Development Review Board 5/16/07 Agenda Item #16
Sketch Plat: Lots 19 & 20, Anderson Addition

**CITY OF ALBUQUERQUE
PLANNING DEPARTMENT
May 16, 2007
DRB Comments**

RE: Lot 19 & 20, Anderson Addition/sketch

**MAP**  
OF  
**ANDERSON ADDITION**  
NO. 2  
TO THE  
CITY OF ALBUQUERQUE, N. M.  
ROSS ENGINEERING OFFICE  
SCALE 1" = 40' SEPT 1921

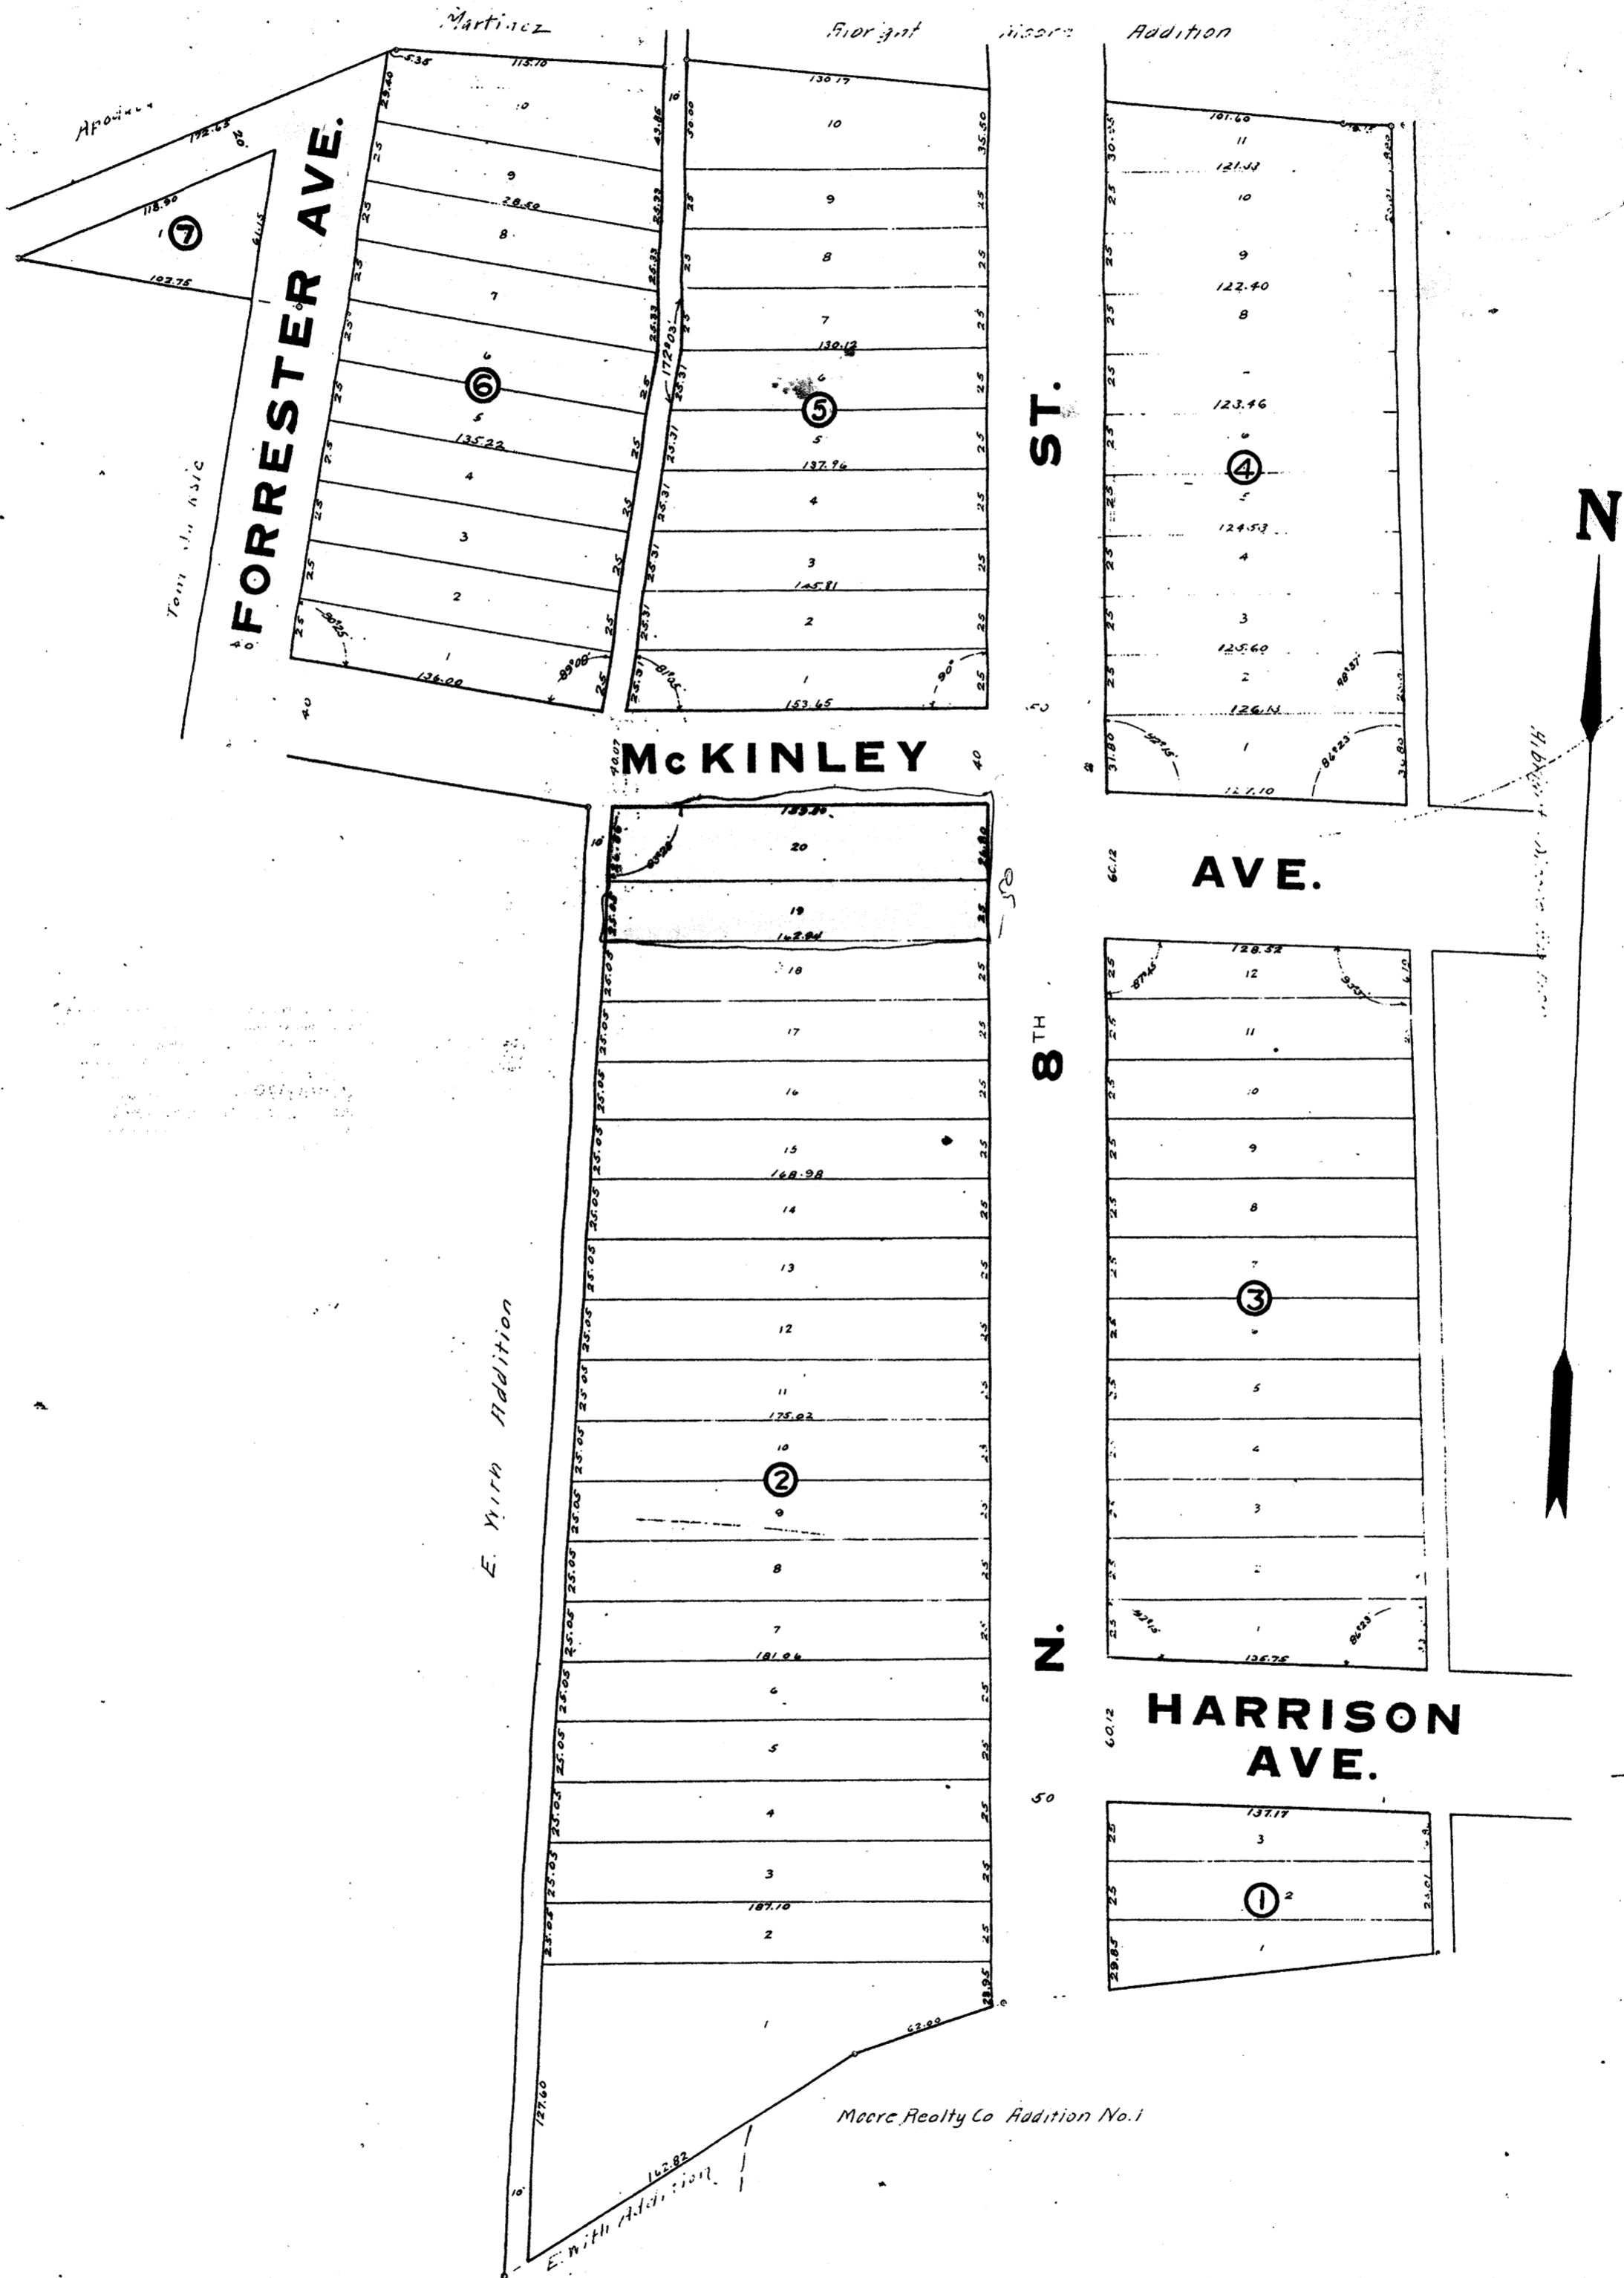
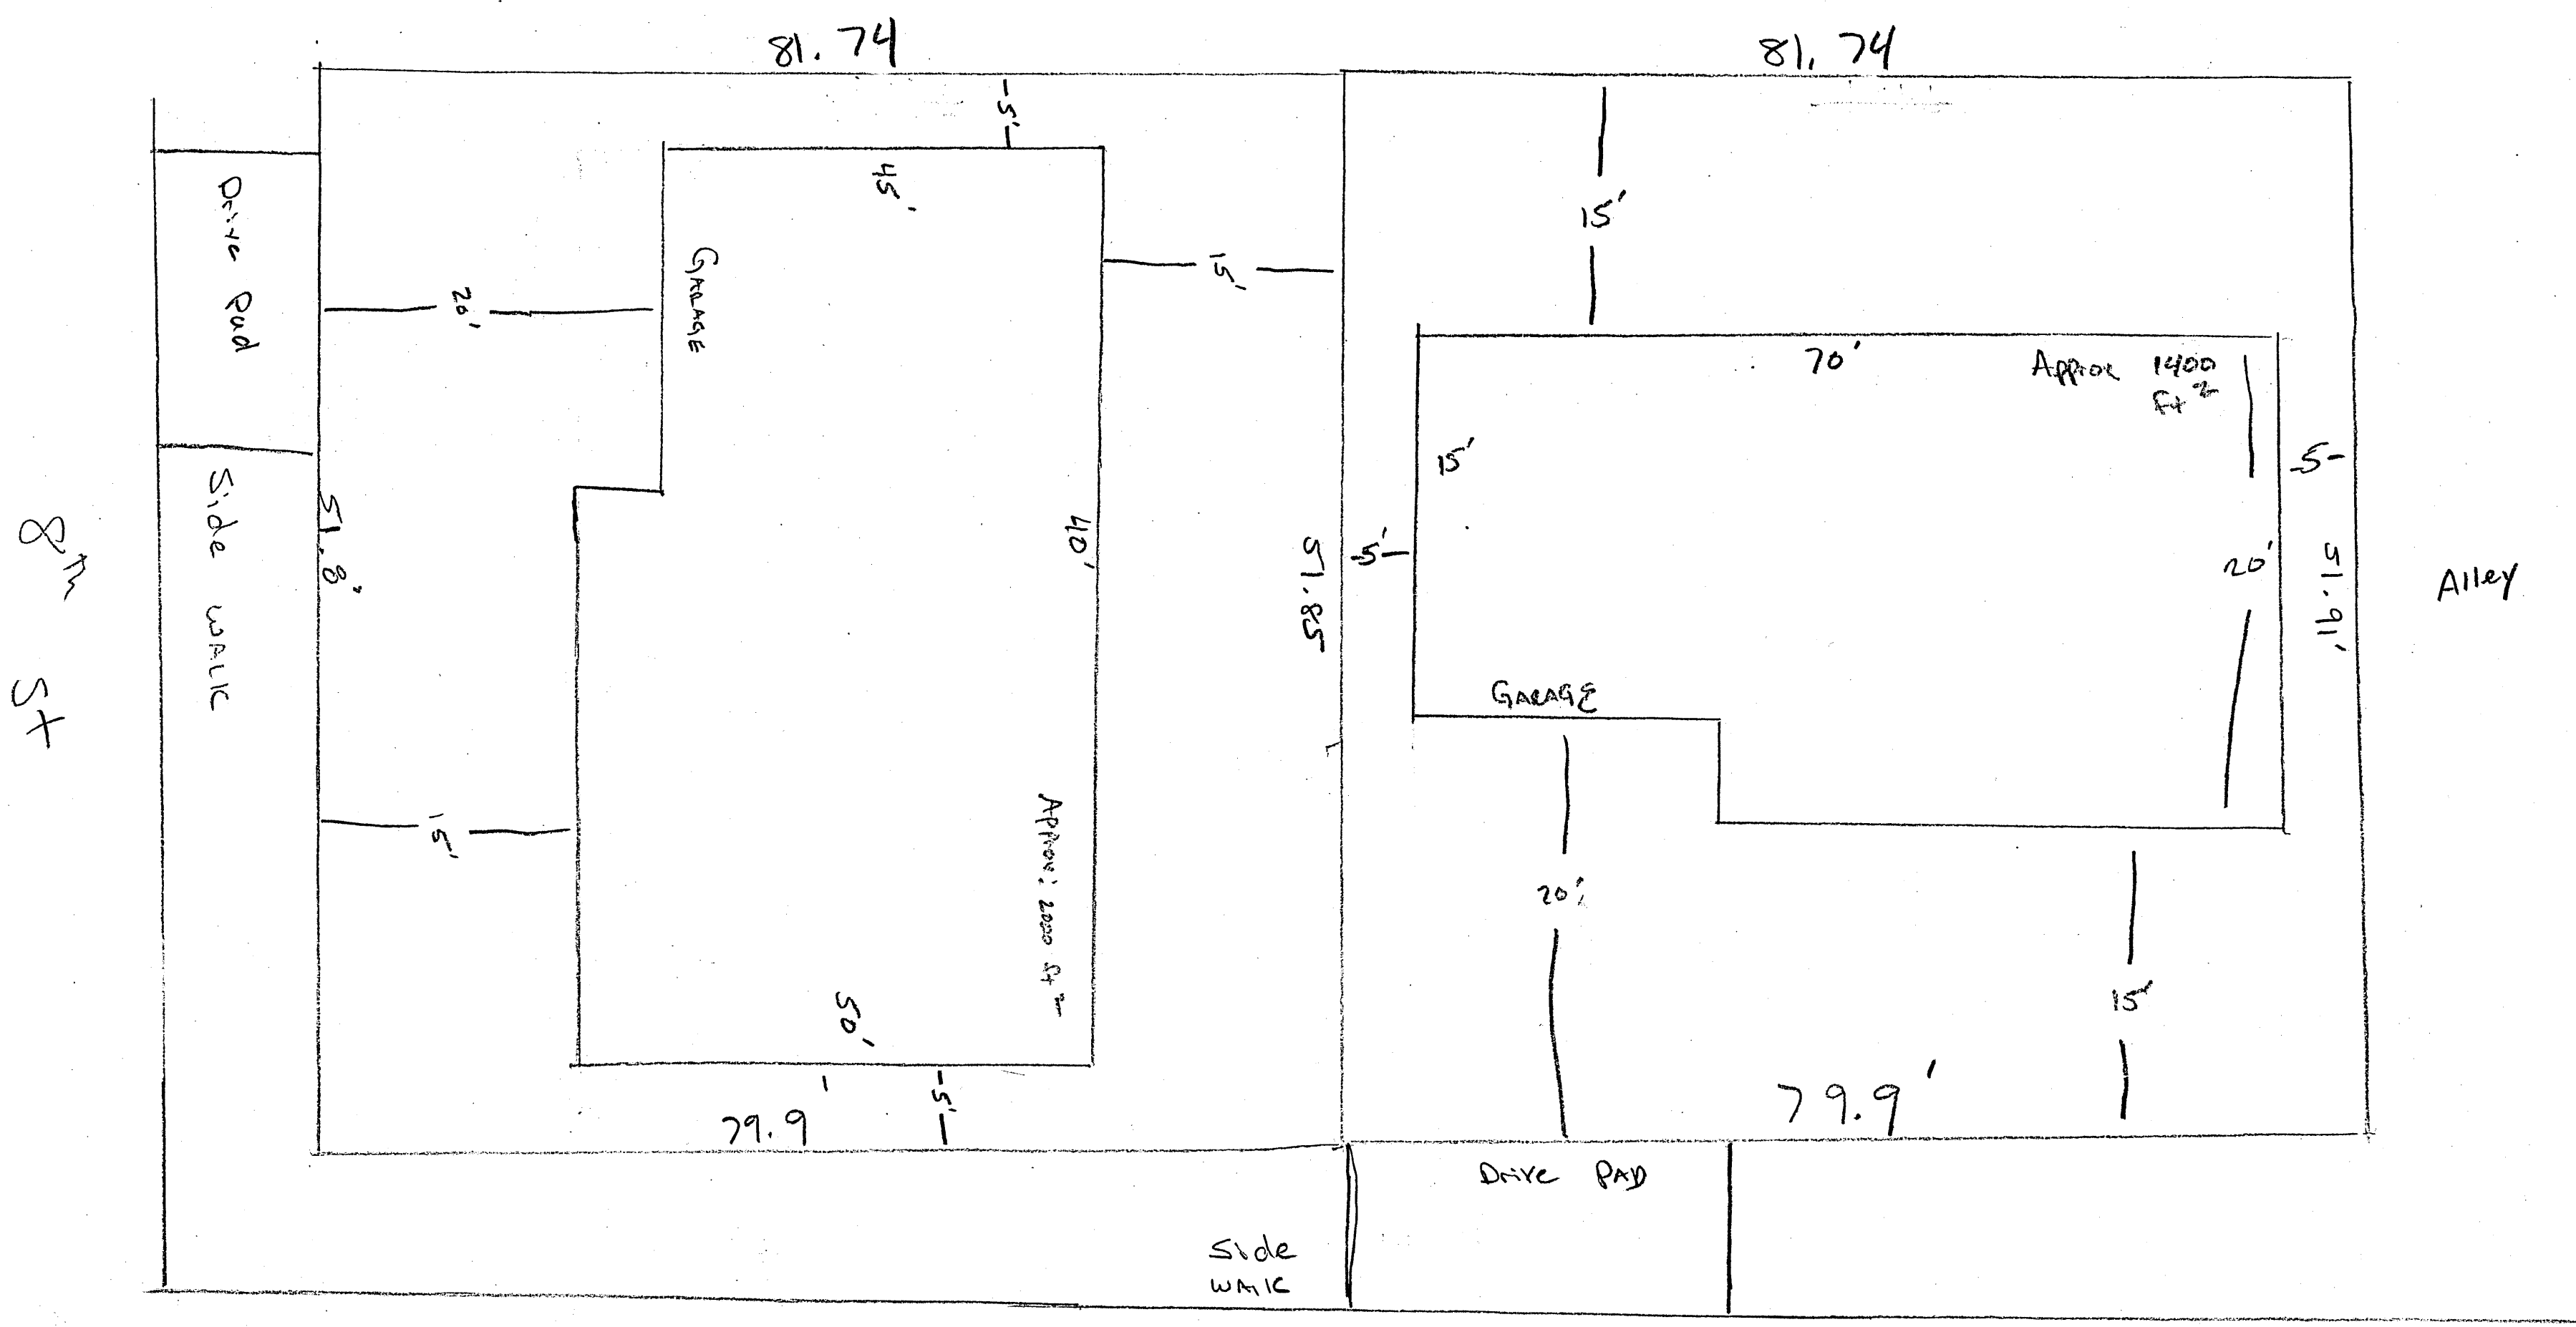
The property is in the Sawmill/Wells Park Sector Development Plan.

The minimum lot size in the S-R zone is 5,000 square feet.
